**KIRKLEES METROPOLITAN COUNCIL
INVESTMENT & REGENERATION SERVICE**

**DELEGATED DECISION TO DETERMINE APPLICATIONS FOR
NON-MATERIAL AMENDMENTS**

Reference No: **2025/NM/92375/E**

Site Address: 47, Turnshaws Avenue, Kirkburton, Huddersfield, HD8
0TJ

Proposed Site Plan
Scale 1:200

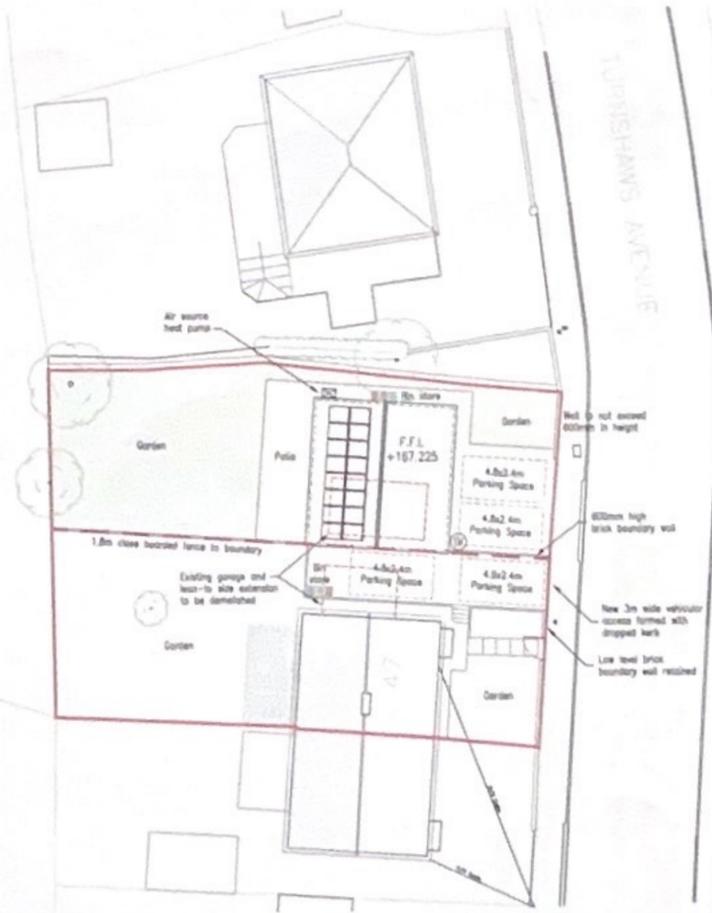
The amendment seeks to retain the existing lean to and amend the parking layout approved.

The amendment sought is to alter the approved parking layout to allow for the retention of the single storey lean to extension of the existing dwelling. The demolition of the lean to was included in the description of development and the parking layout approved and conditioned. Whilst the development remains the same there are concerns regarding the revised parking layout now proposed.

The proposed changes would fall outside of the description of development, which is "Demolition of detached garage and single storey lean-to extension and erection of one detached dwelling with associated parking and landscaping " as the lean-to would be retained with inadequate parking.

The parking layout would not be as approved and would appear to contravene Condition 6 of the original permission that requires the approved parking areas to be provided.

The proposal requires amending to be acceptable as the depth is inadequate.

The proposed amendments would not have been approved as part of the original application. The amended parking is inadequate and would result in vehicles overhanging the footway to the detriment of highway safety.

The amended parking layout is not acceptable and would not be in the interest of highway safety due to lack of space for vehicles to park. An informal discussion was also had with KC Highways who did not consider the amended parking layout to be acceptable from a highway safety perspective for this reason. In order to facilitate retention of the existing lean-to parking spaces could be provided adjacent to each other mirroring those proposed for the new dwelling. This could be regularised through the submission of a new application.
